CITY OF PORTLAND

BUILDING PERMIT

Located At 224 COYLE ST

Job ID: 2012-04-3879-ALTR

TITLE
 DECK PLAN, ELEVATION, DETAILS
 SHEET NUMBER
 1 of 1

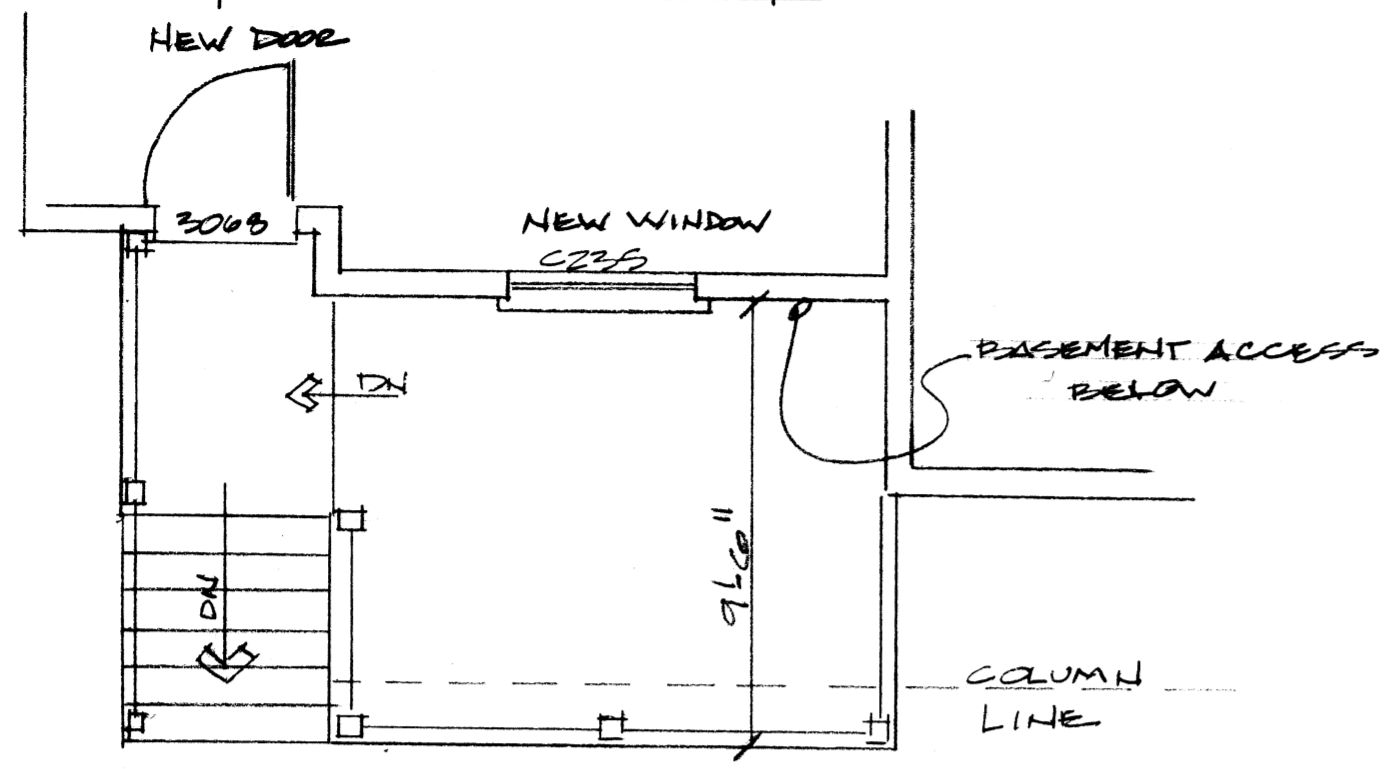
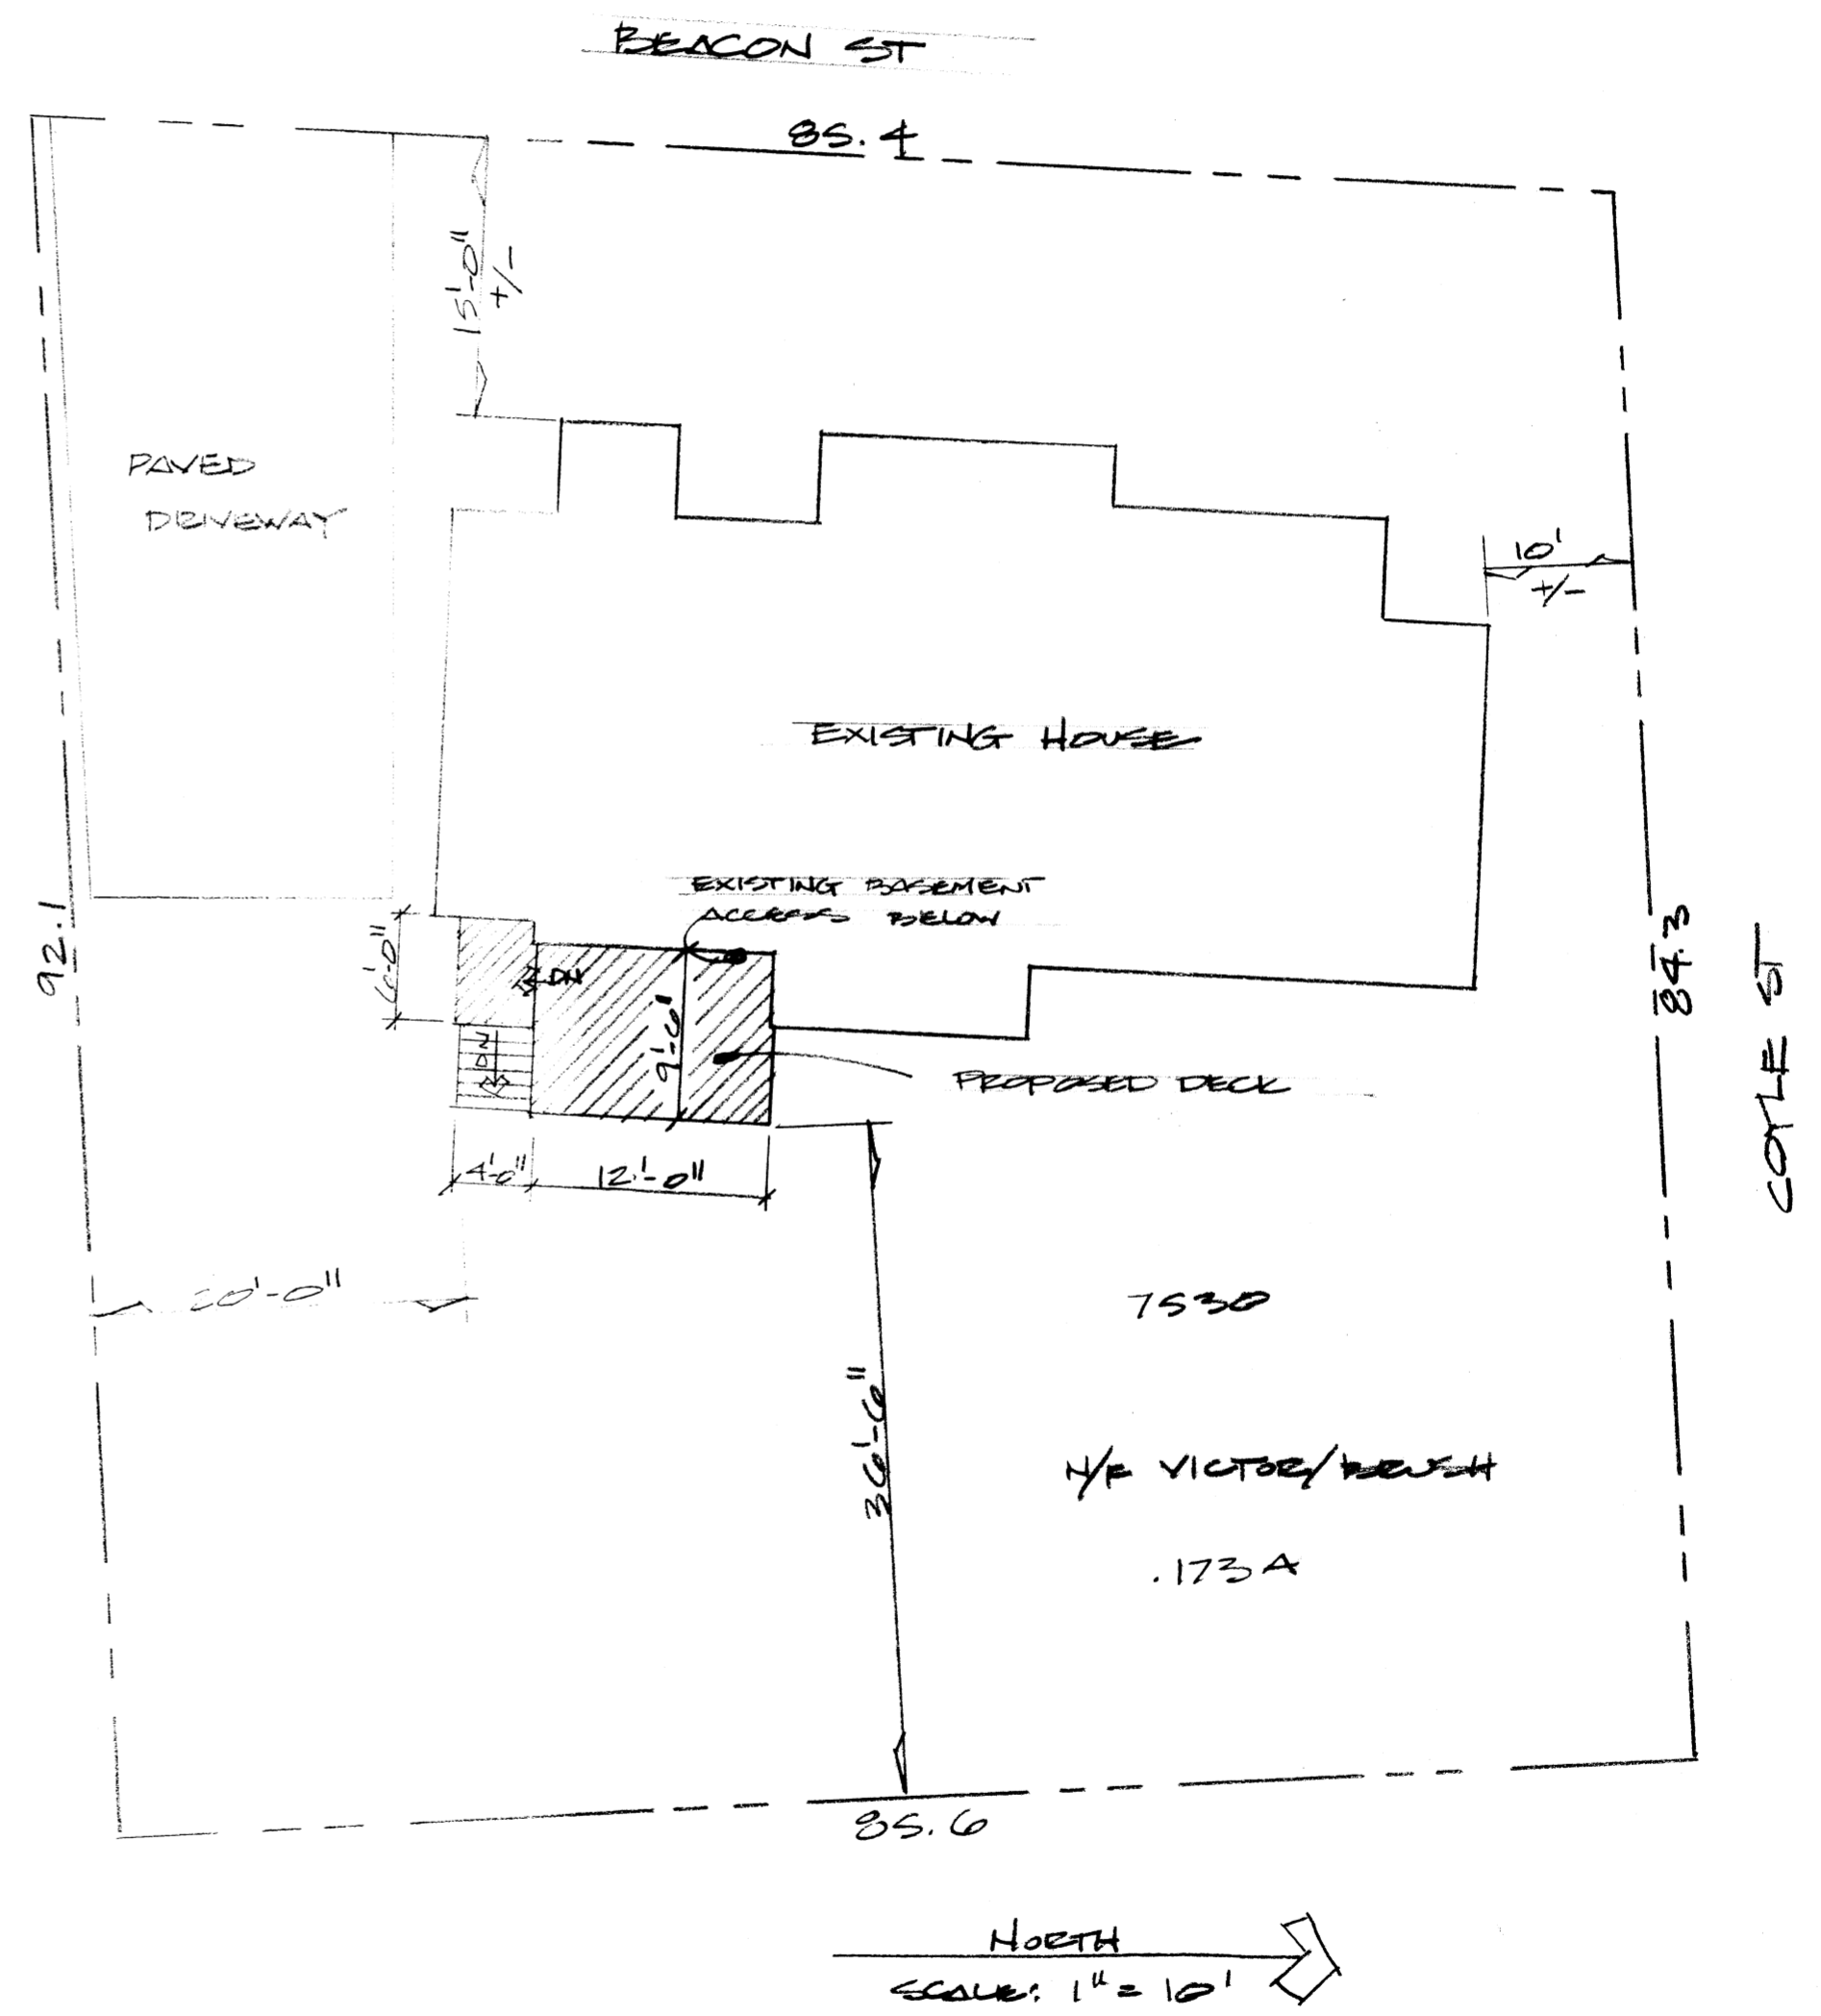
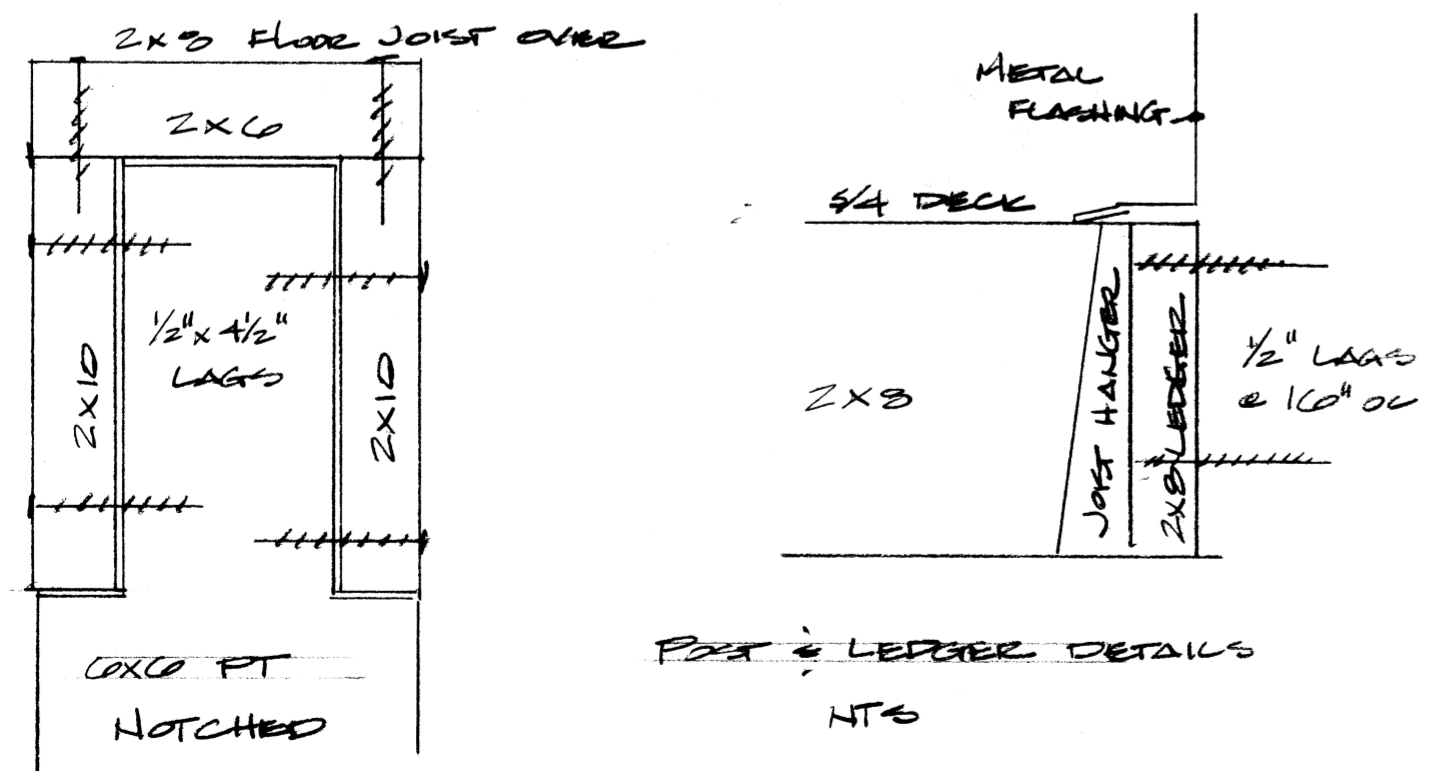
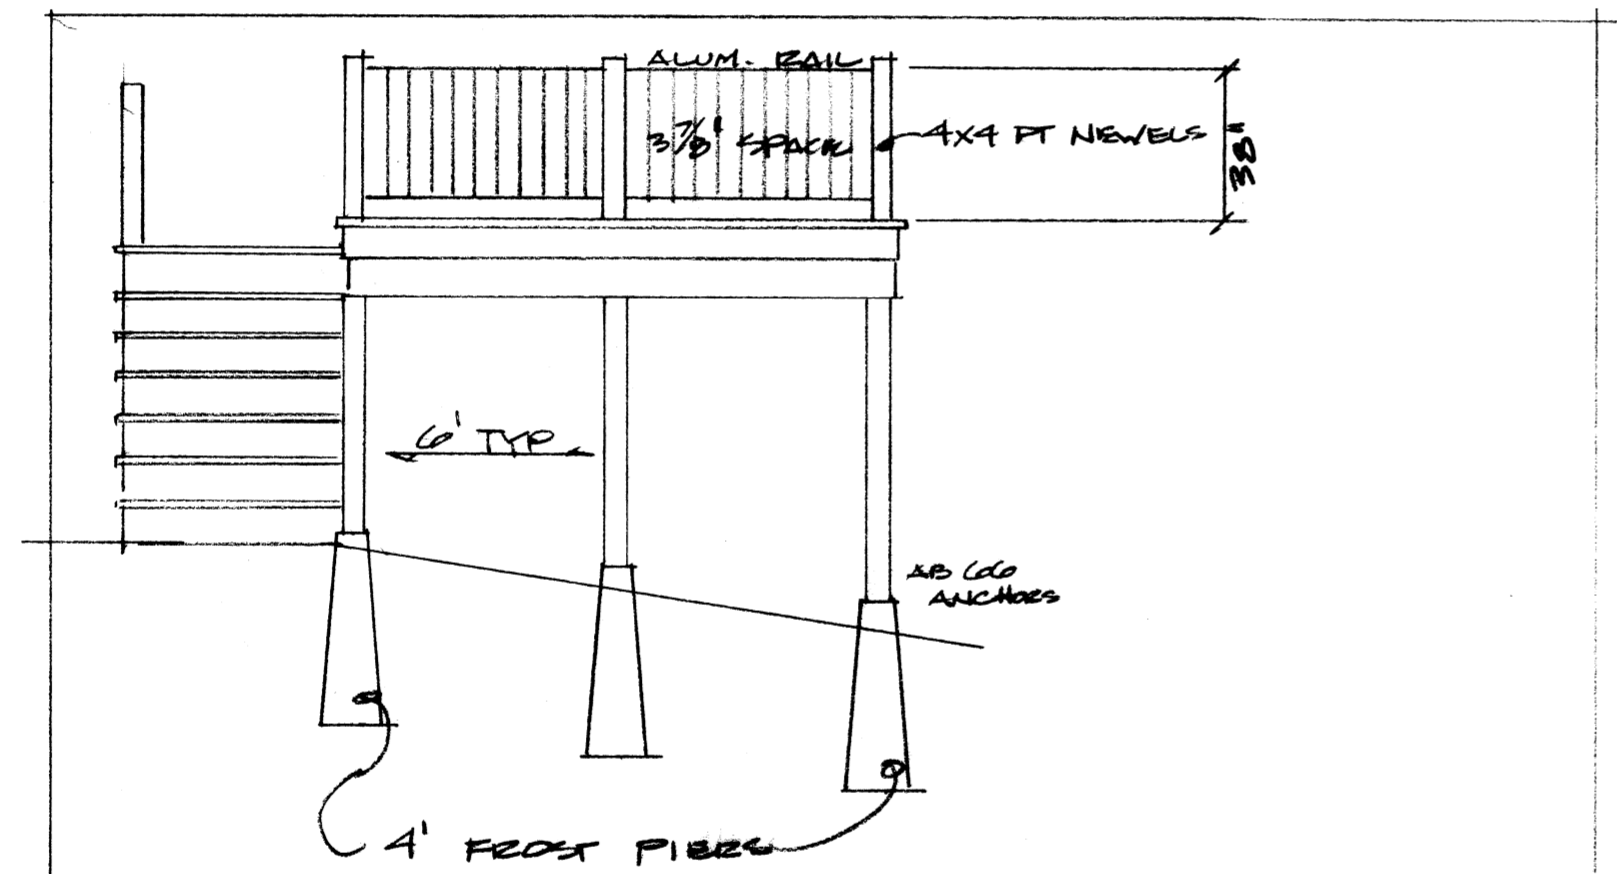
1. This permit is being approved on the basis of plans submitted May 14, 2012. Any deviations shall require a separate approval before starting that work.
2. This property shall remain a single family dwelling. Any change of use shall require a separate permit application for review and approval.
3. This permit is being approved using section 14-425 for the landing and section 14-433 for the stairs.

Are the 2 x 8 inch floor joist 16 inches O.C.?
What are you using for window/ floor headers?
What is the finish window height from the floor?

2x8 joists are 16" on center, with 5/4 composite decking on top. Existing window header will be used (for kitchen window replacement) and 4x6 header for new door in non load bearing wall. Window height above floor will be as old window, approximately 42" AFF.
